May 9, 2023

Re: Duplexes for the Constance LLC
4505 12TH St. NW
Traffic Circulation Layout
 Architect's Stamp 03-15-23 (G14-D080A)

Based upon the information provided in your submittal received 04-28-23, the above referenced plan cannot be approved for Building Permit until the following comments are addressed:

CIVIL101

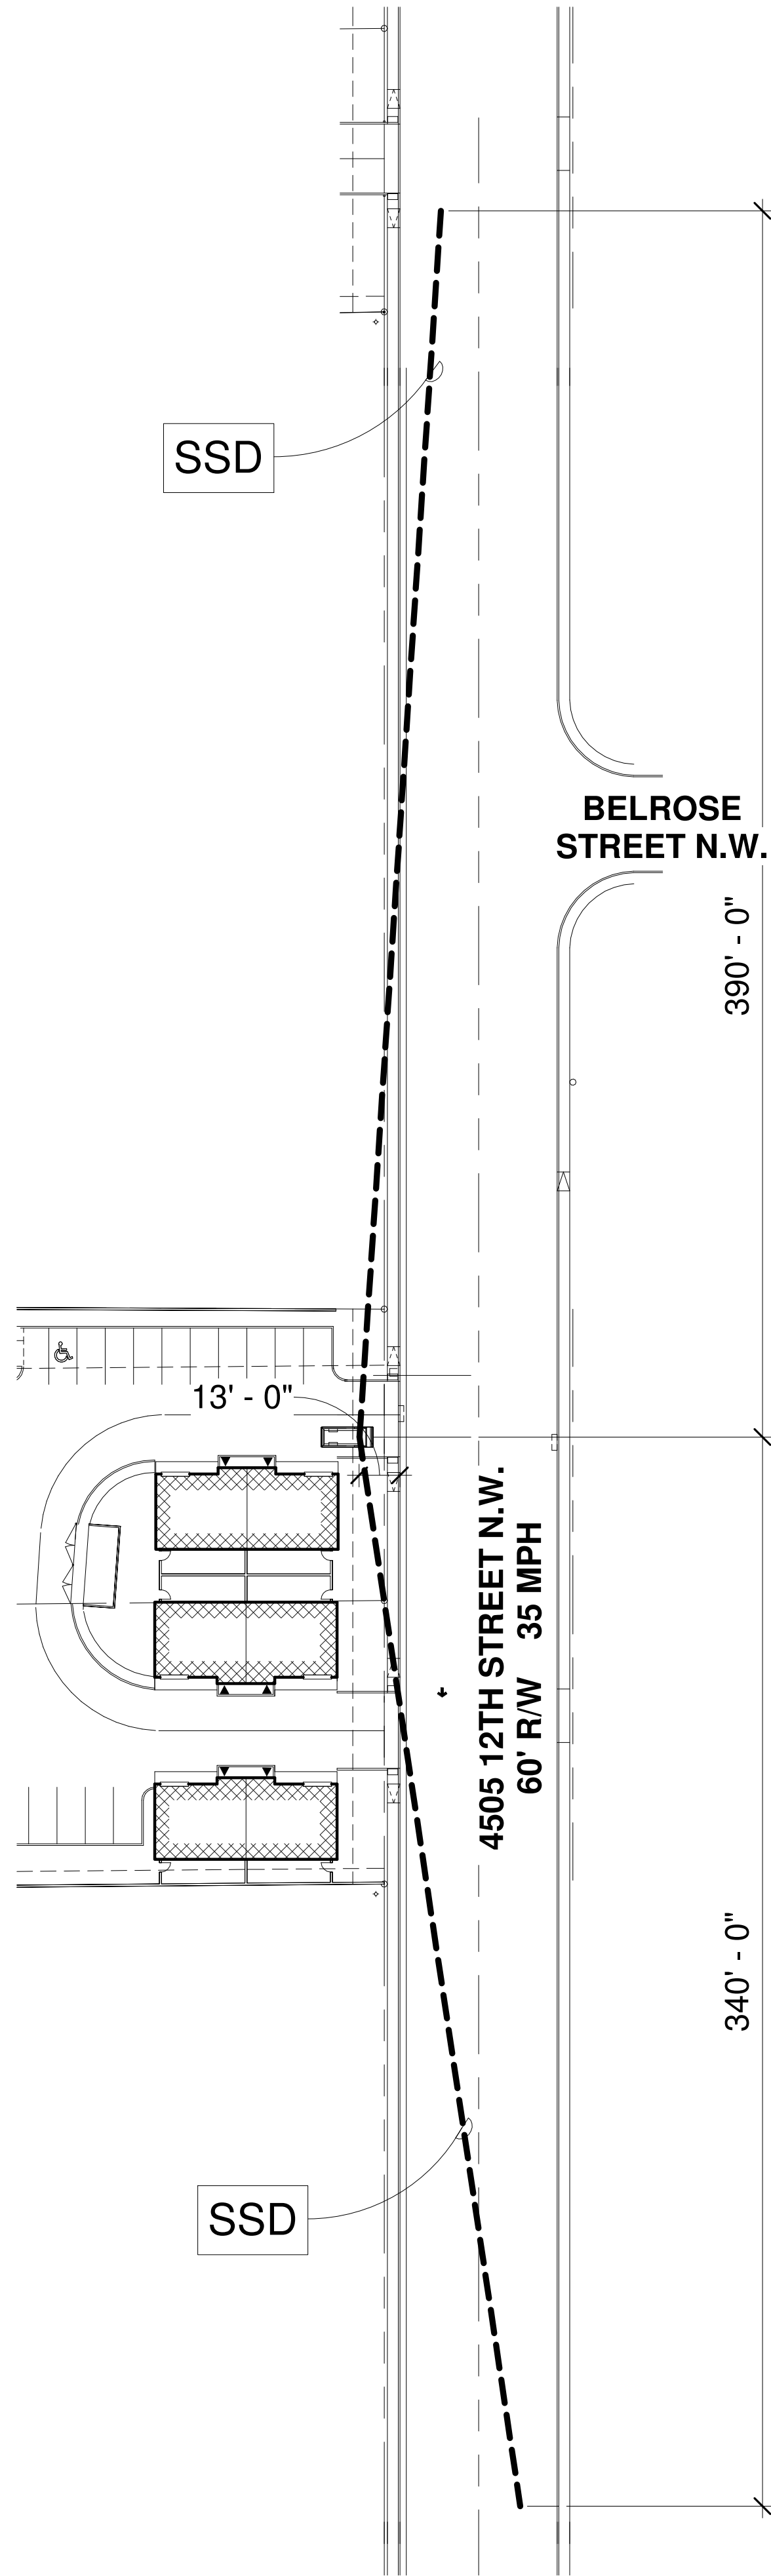
1. Identify all existing access easements and rights of way width dimensions.
2. Please show on the site plan the throat length for the north site access. Per the DPM the minimum throat length should be 25 ft.
3. Please explain how the motorcycle could park in the proposed MC parking. Please provide internal circulation that the driver can easily follow.
4. Provide sidewalk easement for the proposed 4 ft. wide sidewalk at both accesses (see the highlighted area). For sidewalk easement, please contact Carrie Mouck at (505)924-3996 camouck@cabq.gov

5. Per DPM, a 6 ft. wide ADA accessible pedestrian pathway is required from the ADA parking stall access aisles to the building entrances. Please clearly show this pathway and provide details.

6. ADA accessible pedestrian pathway should not be placed behind parking space or adjacent to a vehicular way. Vehicle and pedestrian/wheel chair conflicts should be avoided as much as possible.
7. Work within the public right of way requires a work order with DRC approved plans.
8. Please add a note on the plan stating "All improvements located in the Right of Way must be included on the work order."
9. Please provide a letter of response for all comments given.
10. Traffic Studies: See the Traffic Impact Study (TIS) thresholds. In general, a minimum combination of 100 vehicles entering and exiting in the peak hour warrants a Traffic Impact Study. Visit with Traffic Engineer for determination, and fill out a TIS Form that states whether one is warranted. In some cases, a trip generation may be requested for determination (**Contact Matt Grush: mgrush@cabq.gov**).
